**Subject: Exhibition of EIS - Yiribana Logistics Estate (SSD-10272349)**

## Attachment A – EES response to EIS for Yiribana Logistics Estate (SSD-10272349), 754-770 and 784-786 Mamre Road, Kemps Creek

E2 CORRIDOR ALIGNMENT PLAN
SCALE 1:500

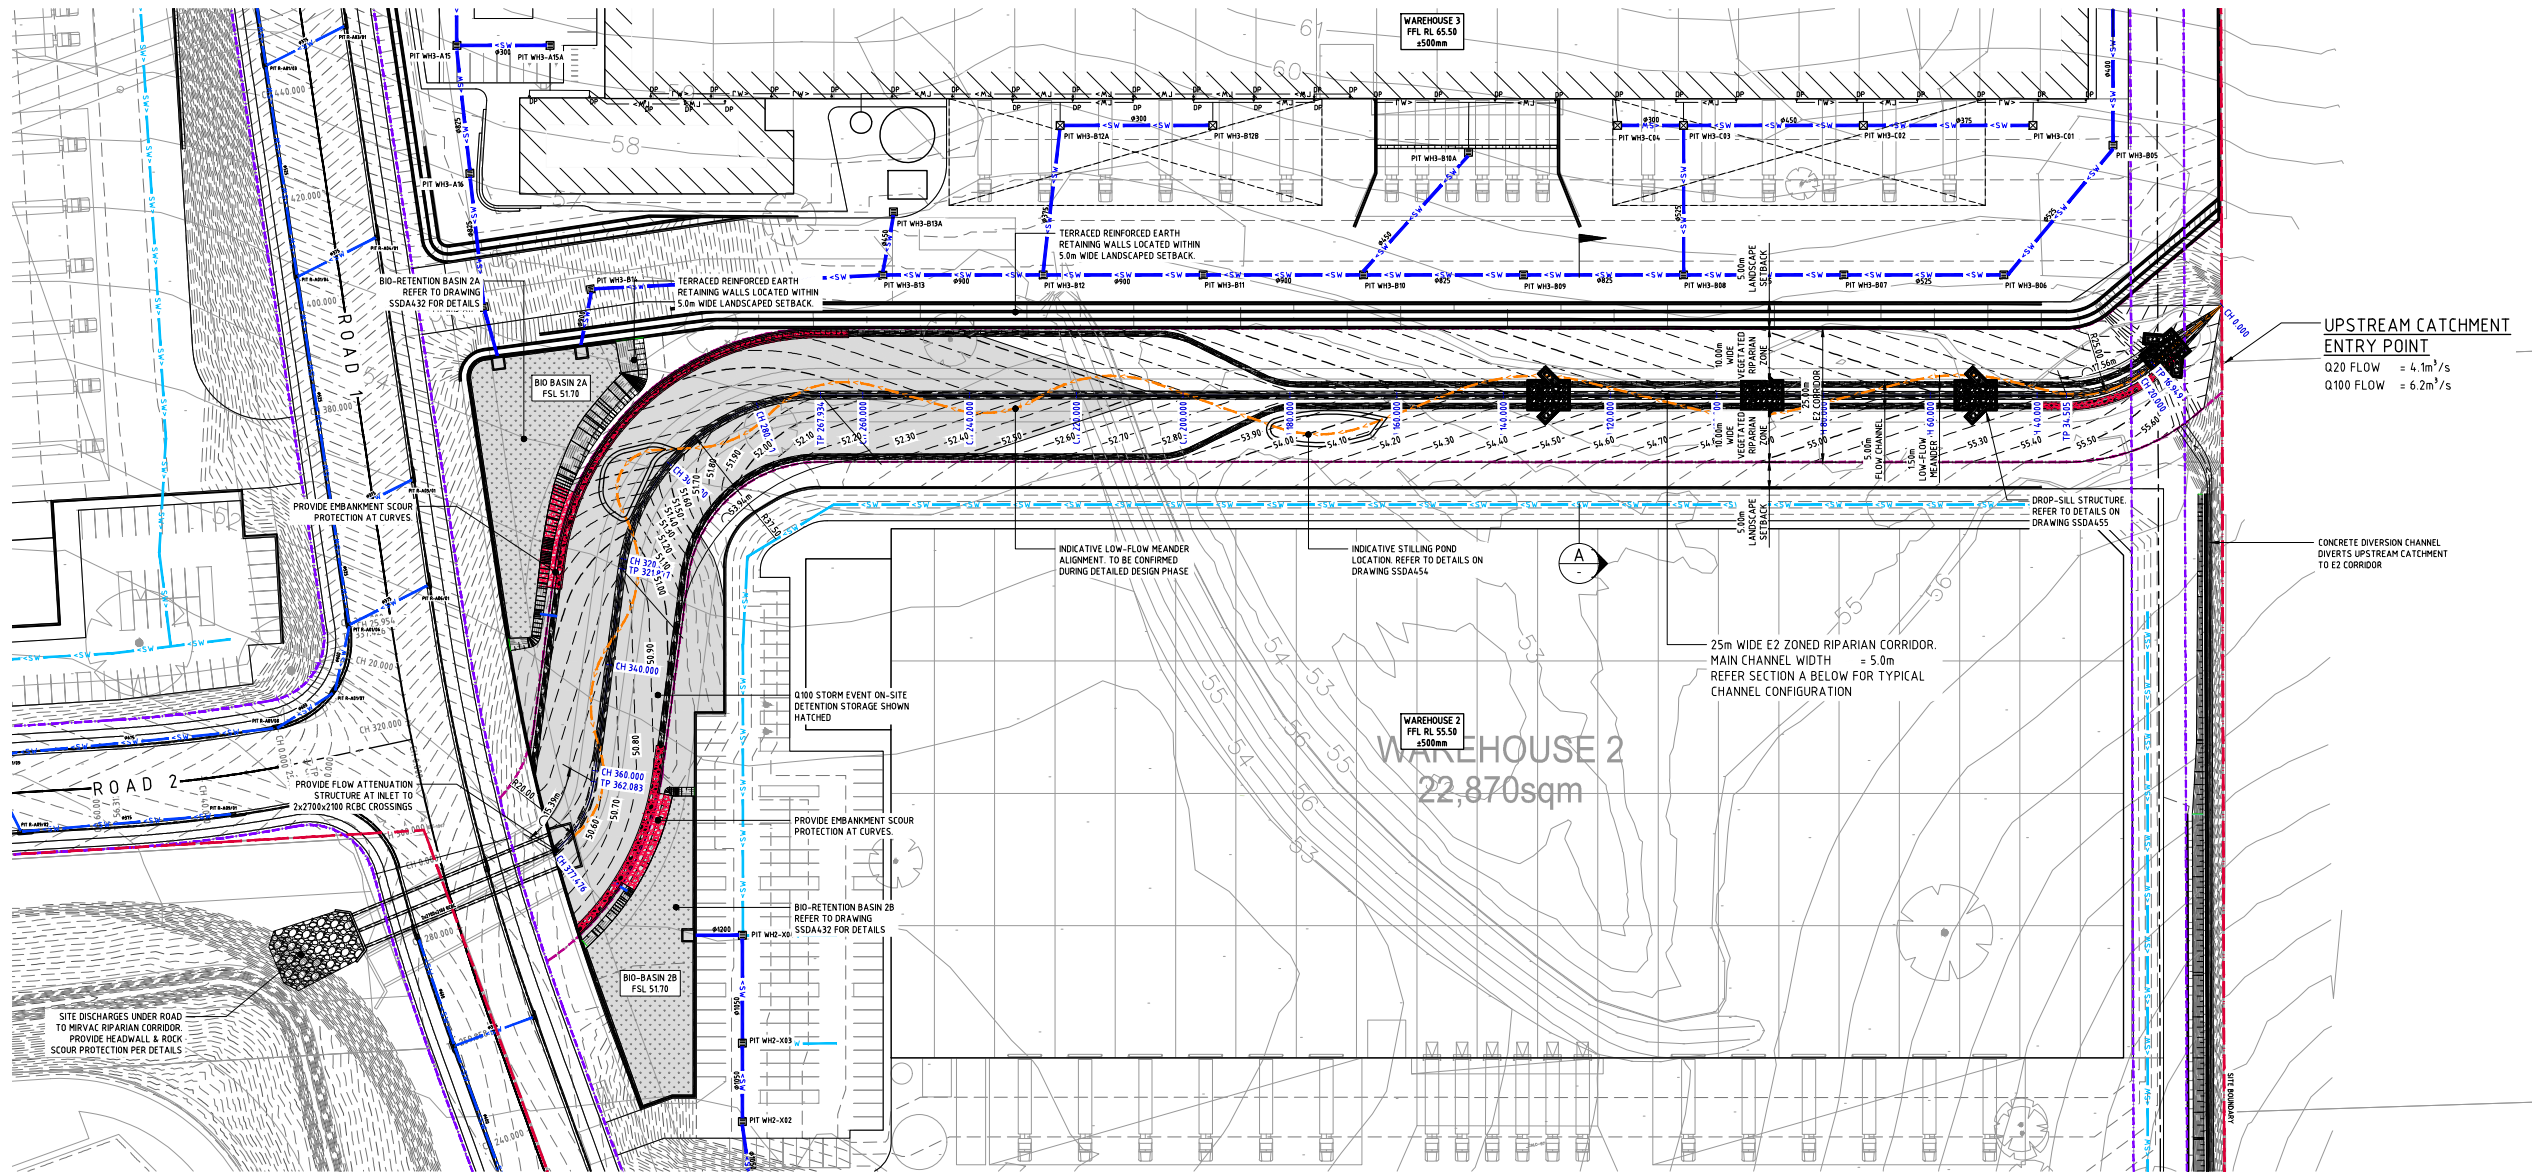
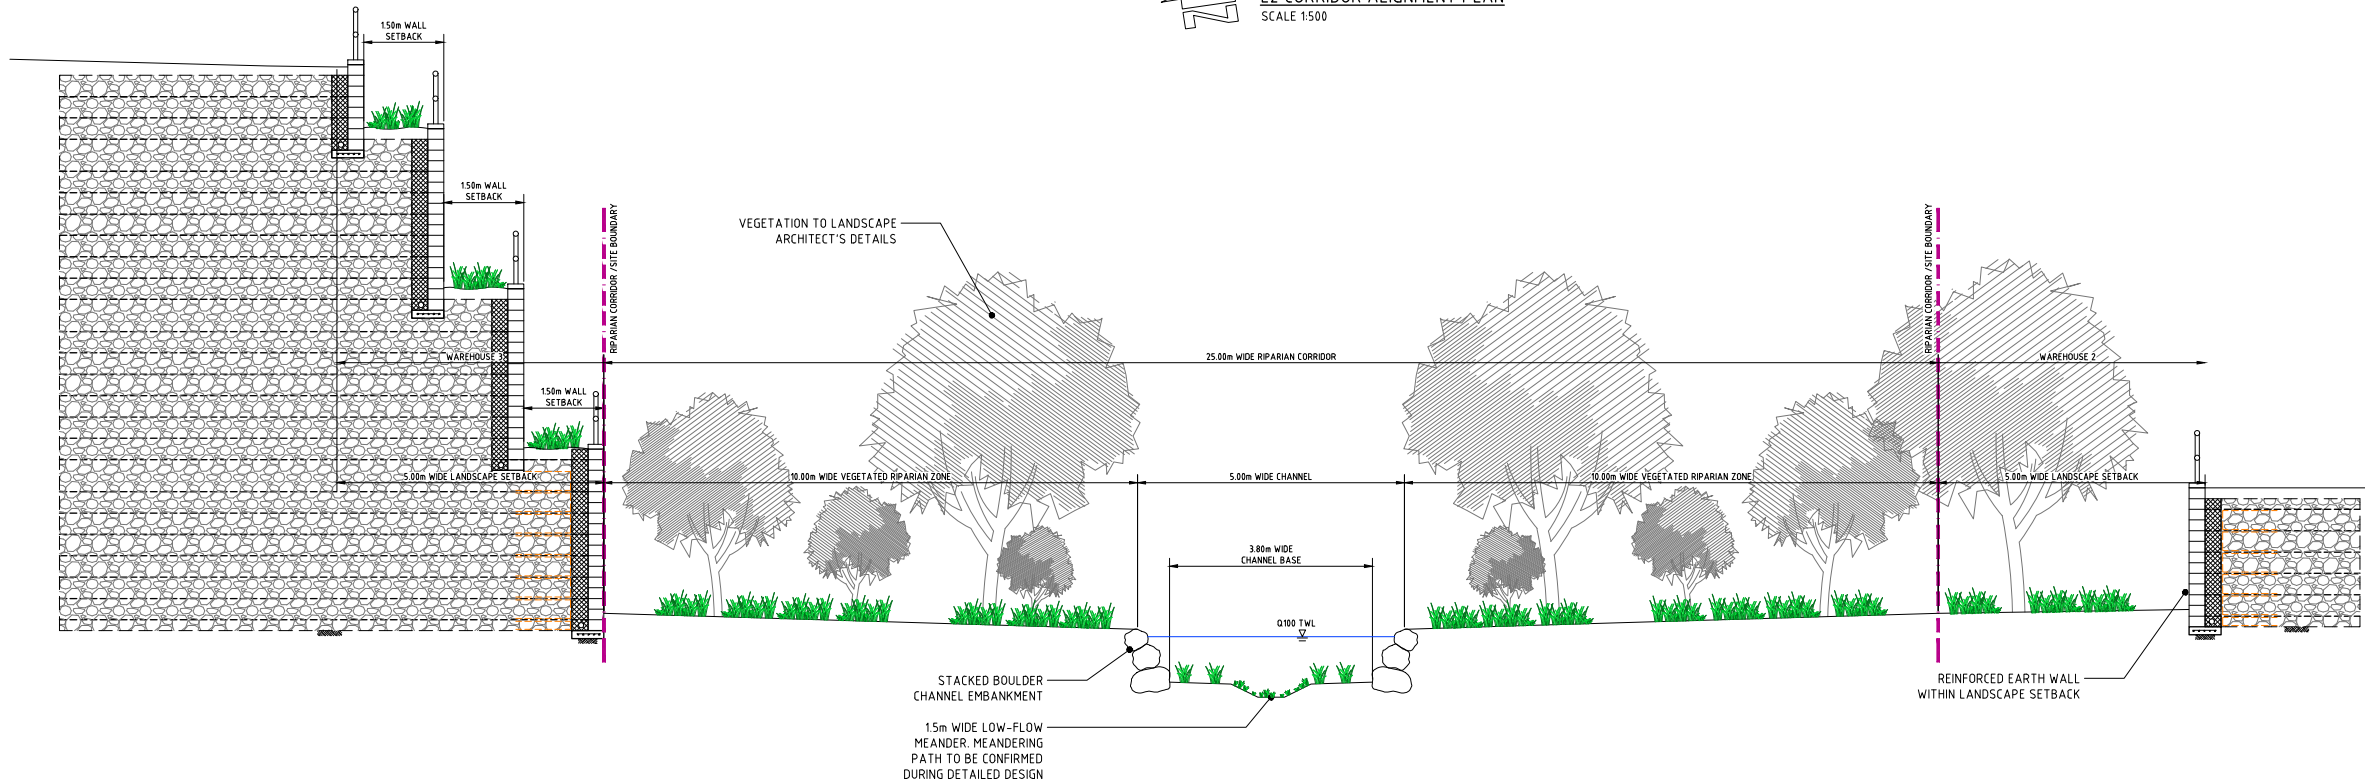
- The proposal includes replacement and realignment of the existing 40m wide E2 zone with a 25m E2 zone within a 35m corridor. EES raises no concern with the proposed realignment of the E2 corridor, however the reduced corridor width is not supported. The corridor/E2 zone must maintain its existing width of 40m.
- A Vegetation Management Plan has been provided for the realignment and reconstruction of the watercourse through the site. How the reconstructed watercourse will integrate/transition into the existing stream on the adjoining property to the east will need to be confirmed. Direct and indirect impacts to native vegetation adjacent the stream within that site are likely from construction and changes in hydrological processes.
